Recommendation Report for Planning Permission for Works or Extension to a Dwelling

REF NO: FP/220/19/HH

LOCATION: 14 Sea Drive
Felpham
PO22 7NE

PROPOSAL: Single storey extensions to front and rear elevations, all existing windows/doors/balcony to be replaced and new slate roof

Front Elevation - Facing South

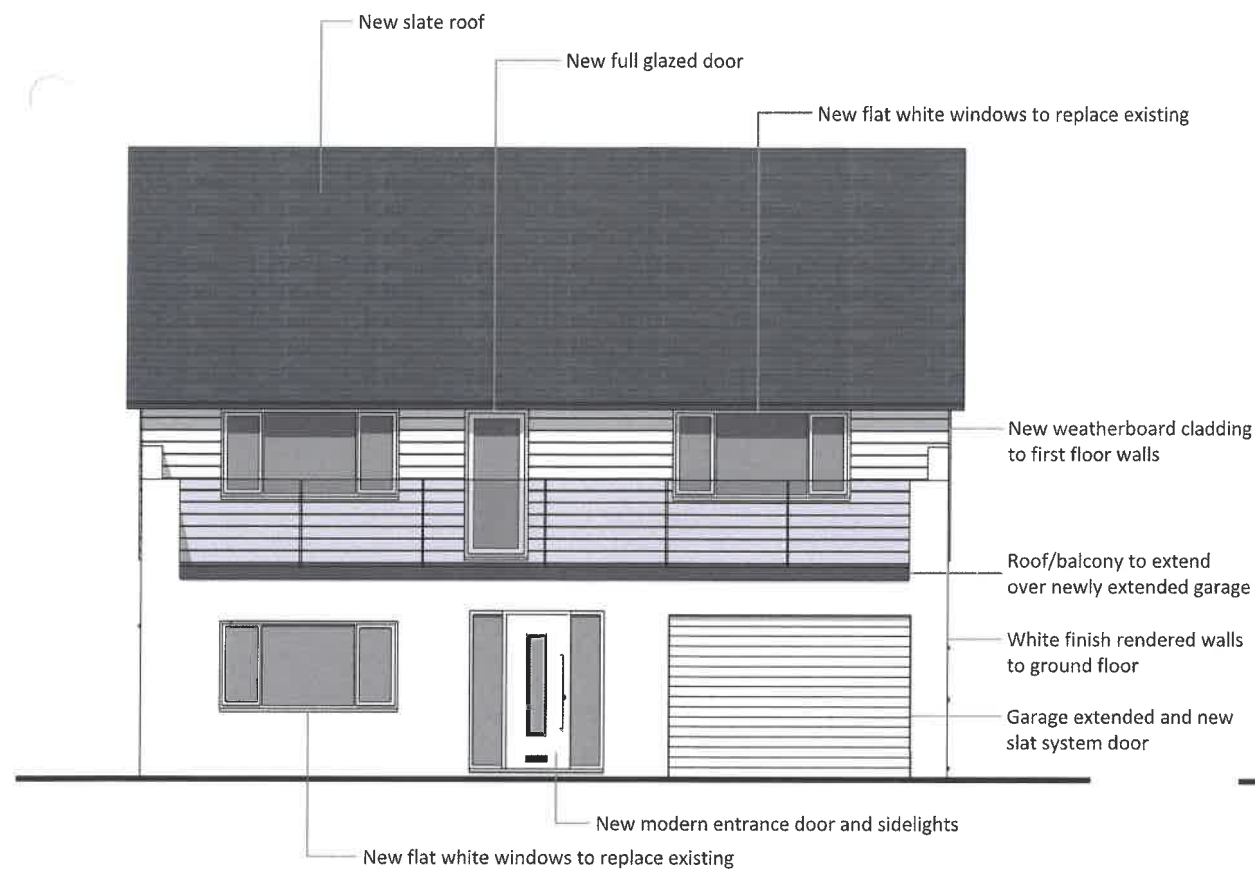
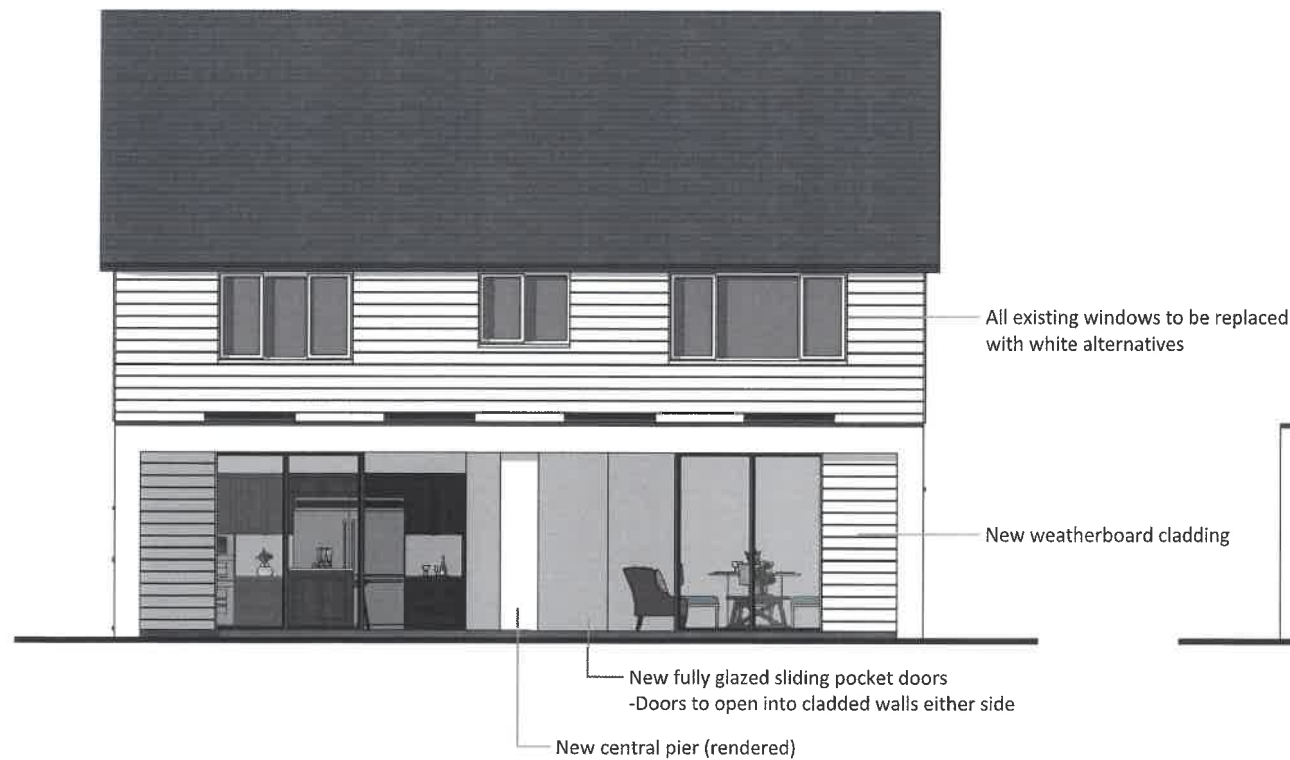
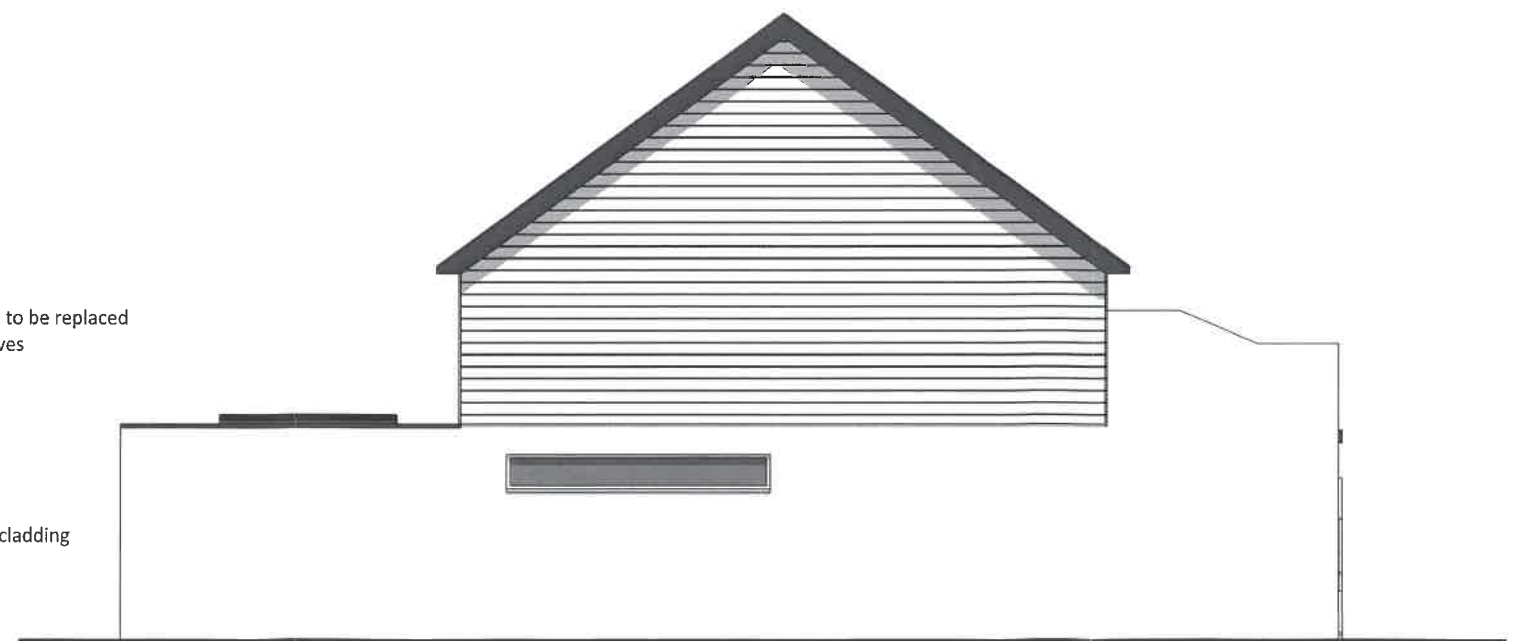
- It is not clear that balconies have obscured glass to 1.5m in height.

The proposal seeks a front extension with a balcony which will be visible from the street scene. There is an existing balcony to the principal elevation however the width will increase in such that it extends the full width of the front elevation of the dwelling. The depth will remain as existing.

The existing front extension will increase in width by 4m to meet with the eastern side elevation. There will be screening to the east to match that in existence at the western side. Due to the siting of the balcony at the front of property, the views are of the street scene. The neighbouring dwelling to the east is also set further back than the host dwelling and as such, the extended balcony is not considered to result in adverse impacts in terms of overlooking.

Comments noted. The balcony is situated to the front of the property and has screening to the east and west elevation which is sufficient to restrict views.

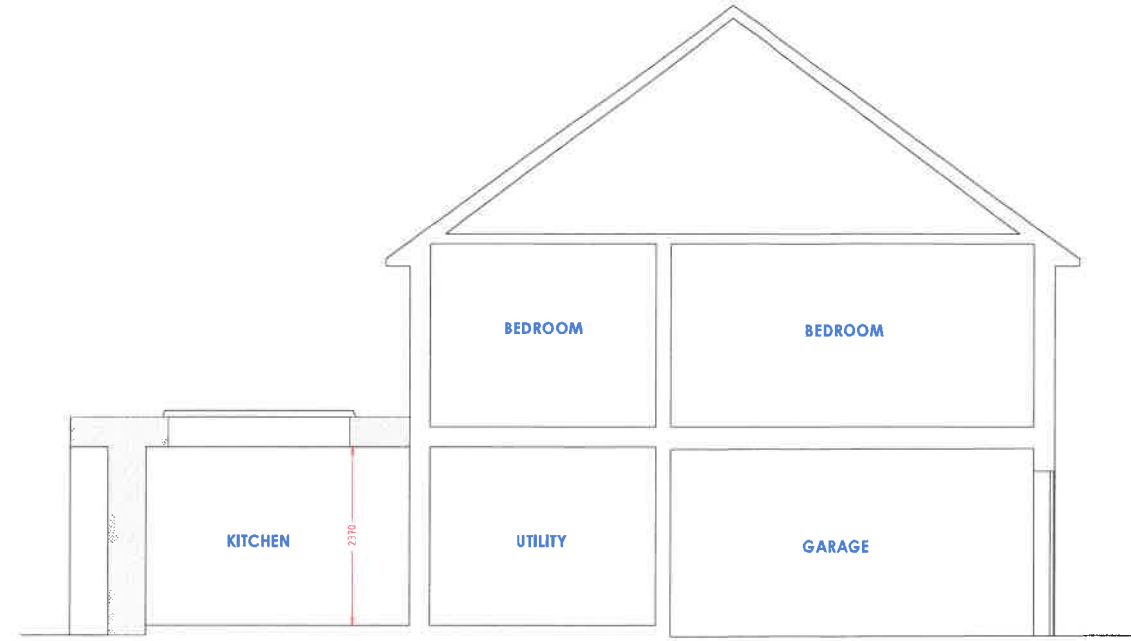
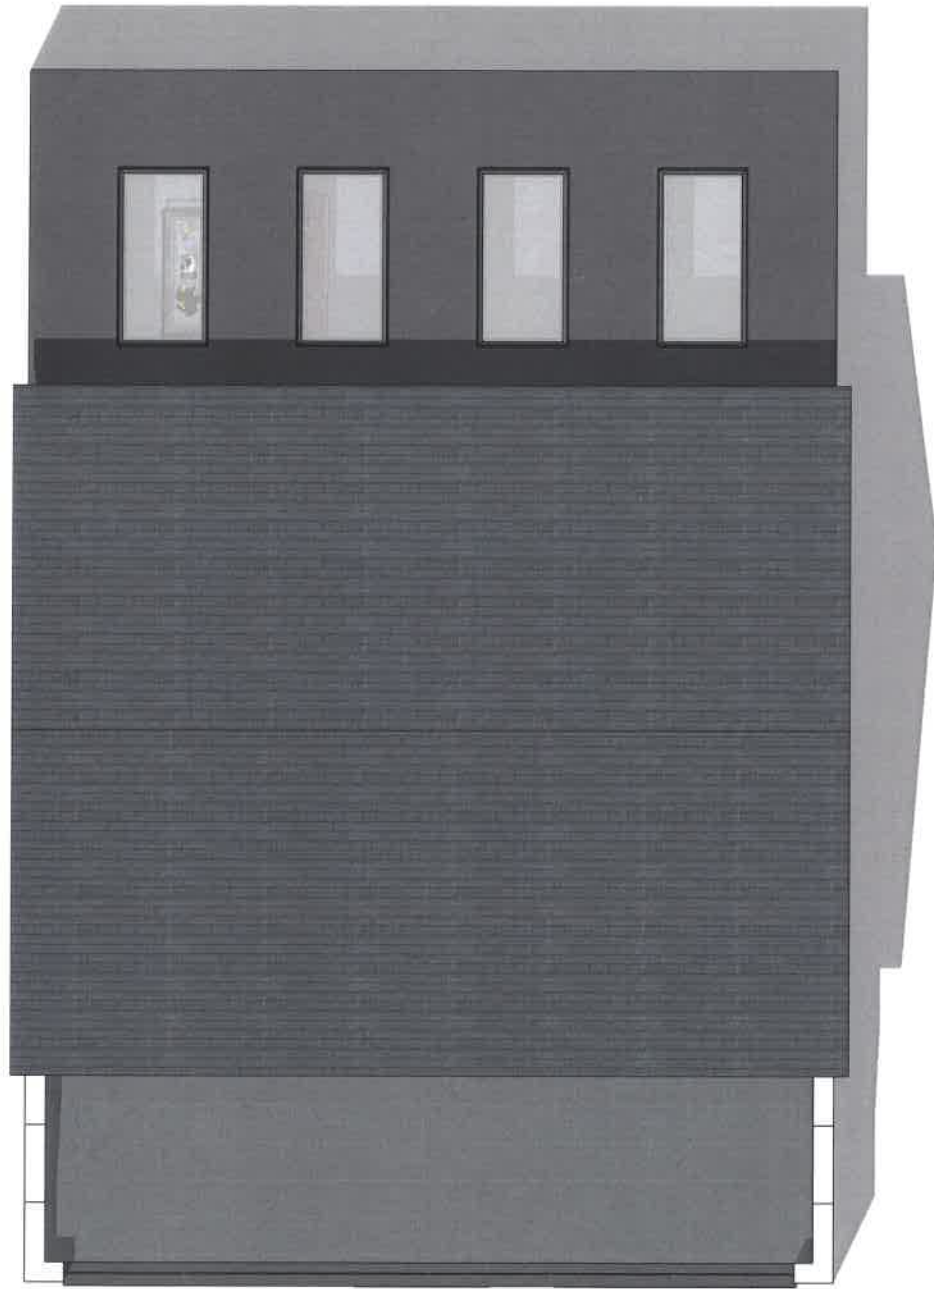
An existing sun room will be replaced with a rear extension. This will increase in depth to 4.5m and will run the full rear elevation with a flat roof, to a height of 2.85m. There is 1m retained to the side boundaries and the development due to its modest size and design is not considered to give rise to adverse impacts.
